Application for a Non-Material Amendment Following a Grant of Planning Permission

P23/02447/F

I refer to planning application ref. P23/02447/F at 17 Gloucester Road North, Filton, Bristol, BS7 0SG. SGC granted the application for 'Installation of 2no. front dormer windows, 1no. rear dormer window with balcony and erection of a single storey rear extension with roof balcony to facilitate the formation of 3no. new flats (Class C3) and partial change of use from Class E to Class C3 living accommodation with other associated works' on 13 October 2023. I attach the decision for your reference.

Scale(s): 1 : 50	Size: A1	Date: 20/04/23	Drawn by: AW
Drawing number: P21853 /P/320	Revision: F	Chkd by:

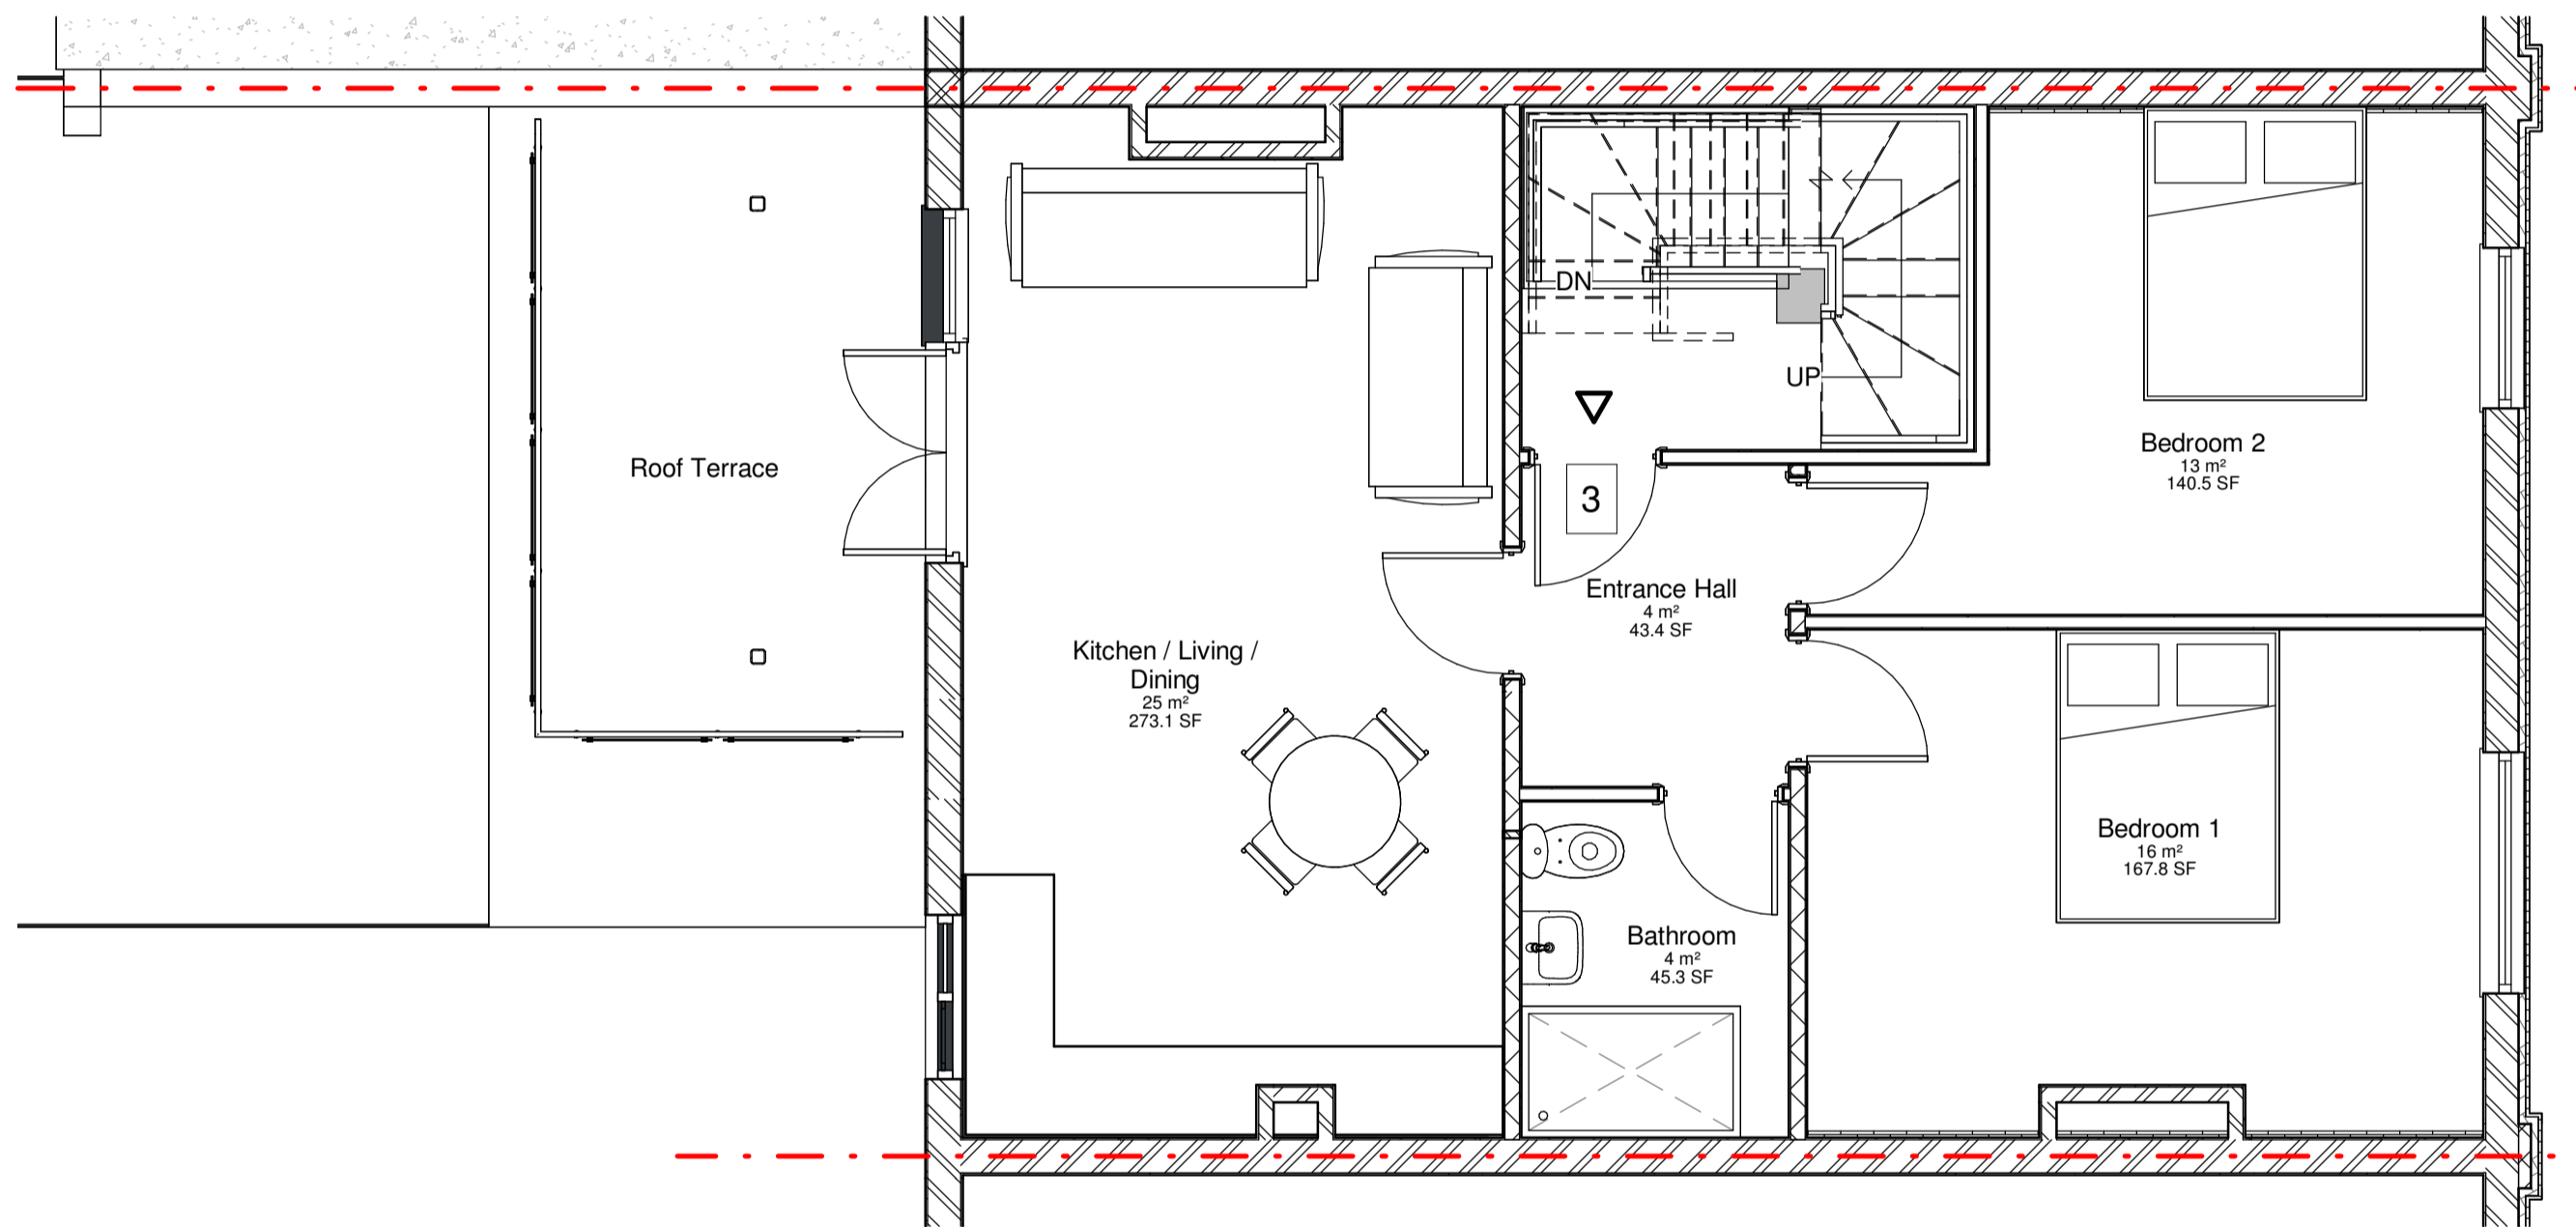
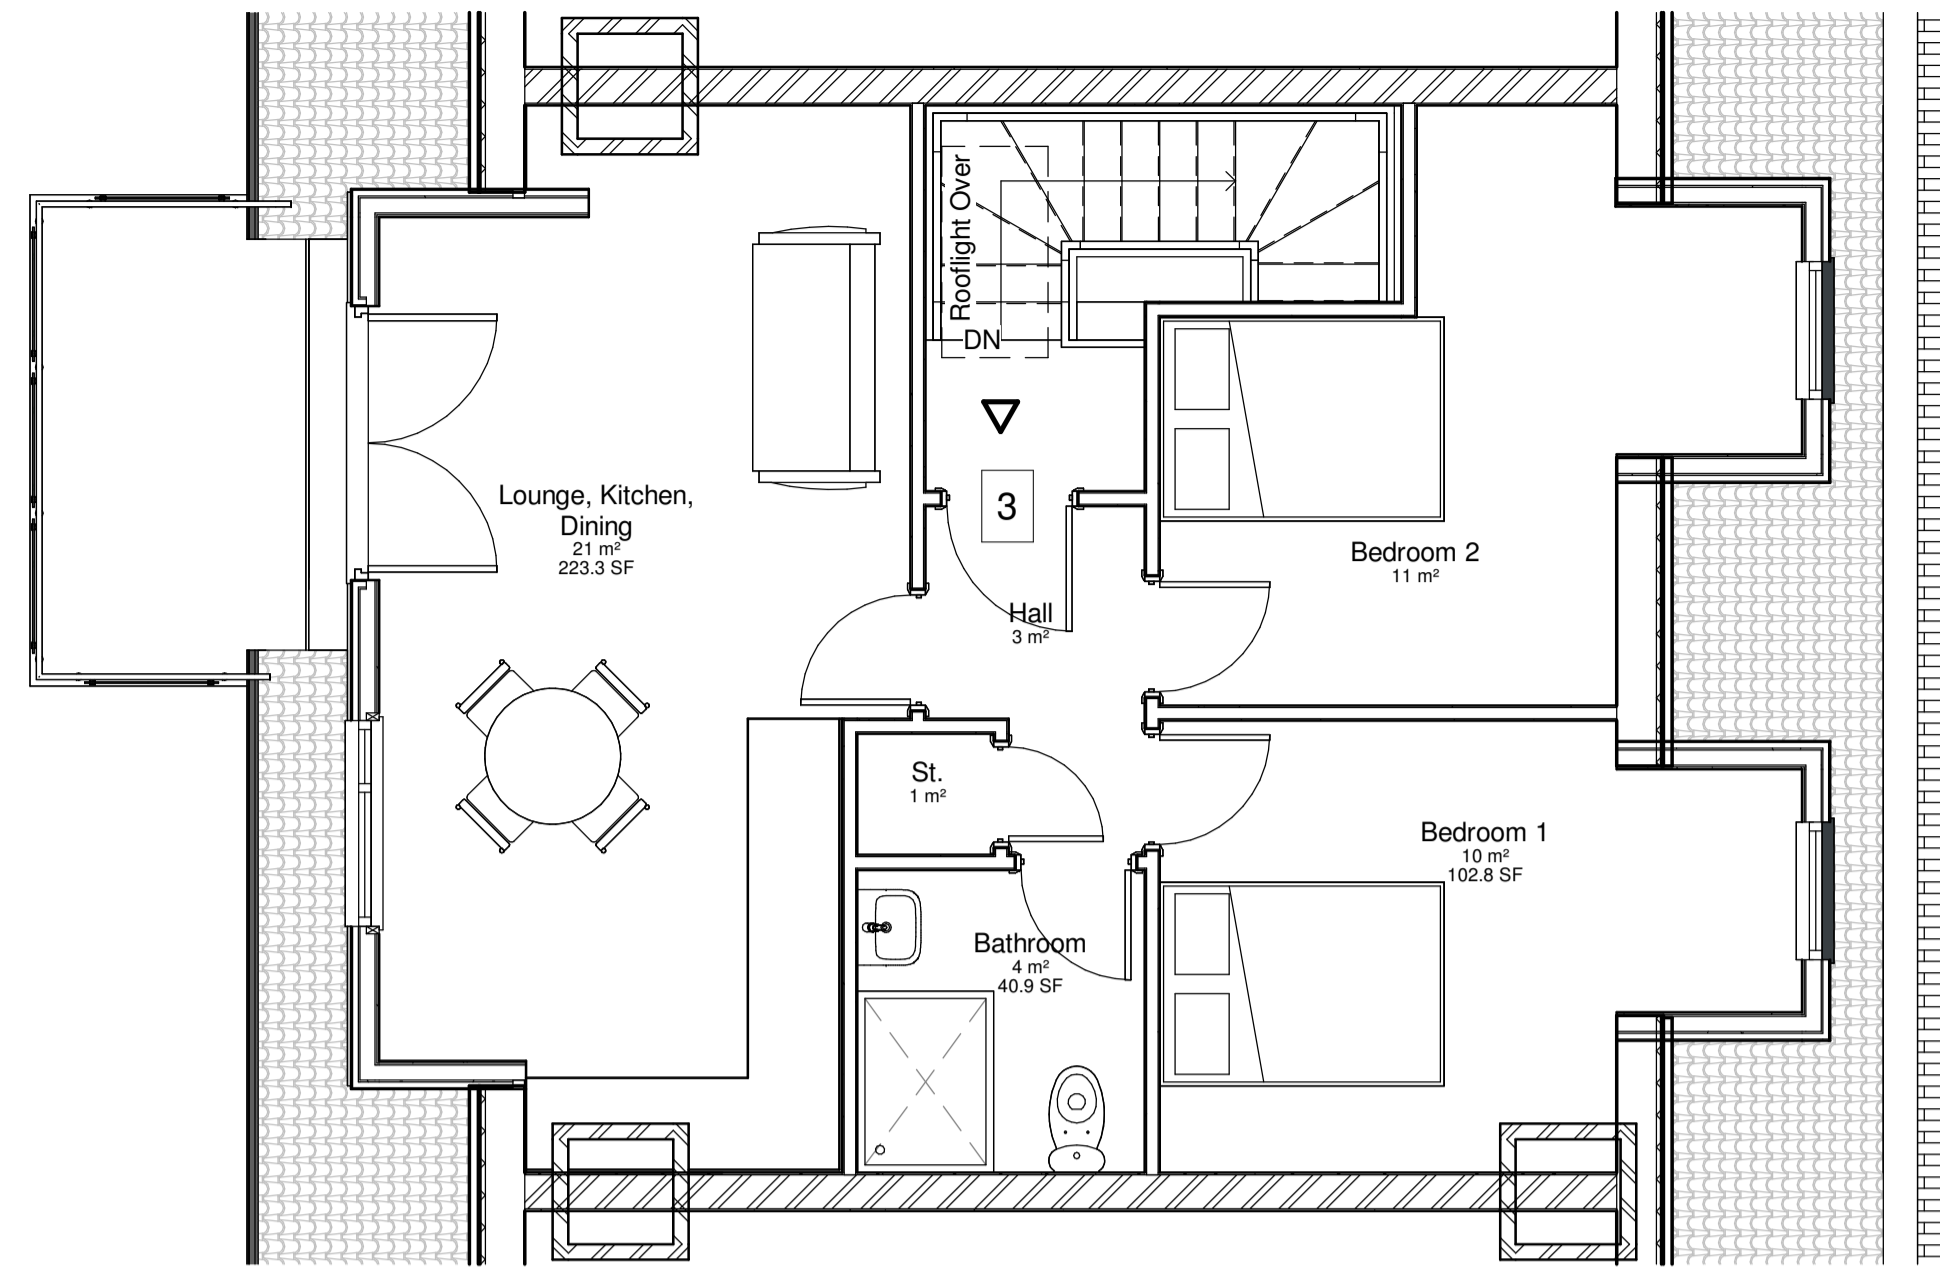
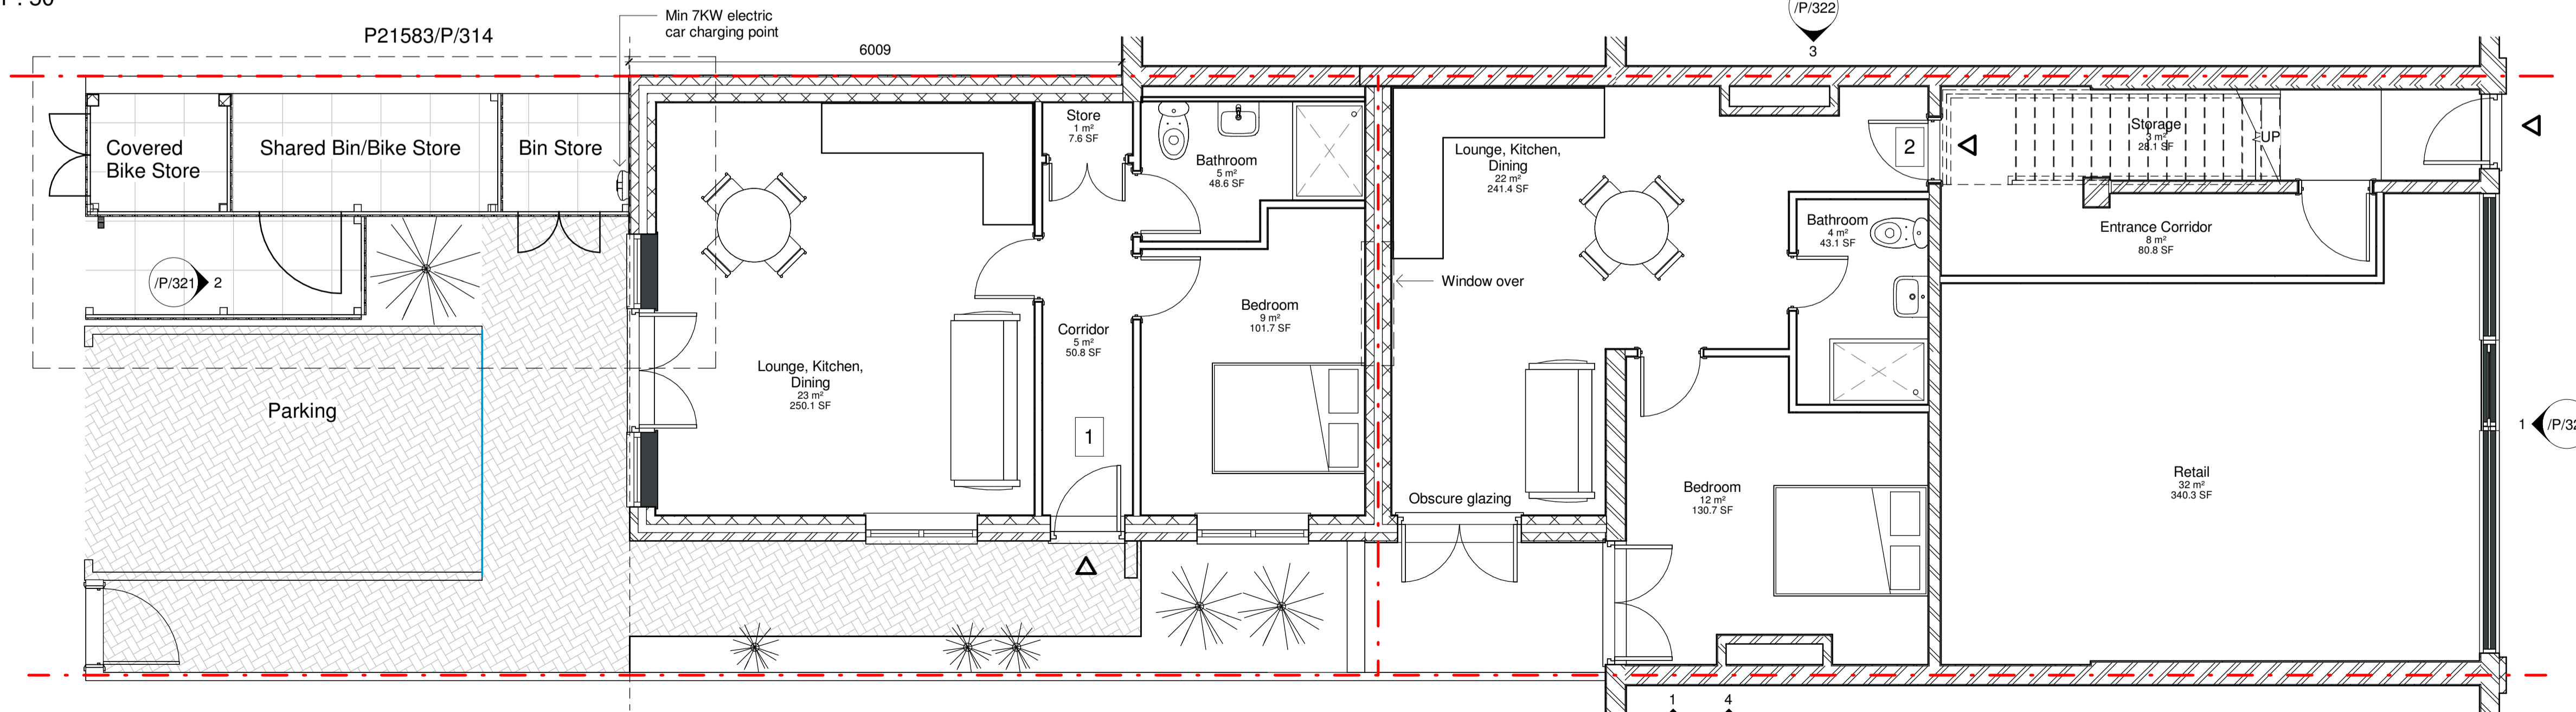
- Unit 1 (ground floor unit at rear of property): Permitted rooflights in living room and bedroom are omitted.
- Unit 2 (ground floor unit behind retail unit): Unit is replanned. Permitted rooflight is omitted. A high level window is proposed from the living room allowing for far reaching views. External double doors from the living room (obscured to prevent overlooking to neighbouring garden) and bedroom will allow natural light to enter the rooms.
- Unit 3 (second floor unit): Permitted roof terrace is slightly different shape, which is acceptable because the rooflights at Unit 1 are now omitted.

P21853 /P/320 Rev F – Ground floor, first floor, second floor plans (Replacing approved plan P21853/P/320 C - proposed floor plan)
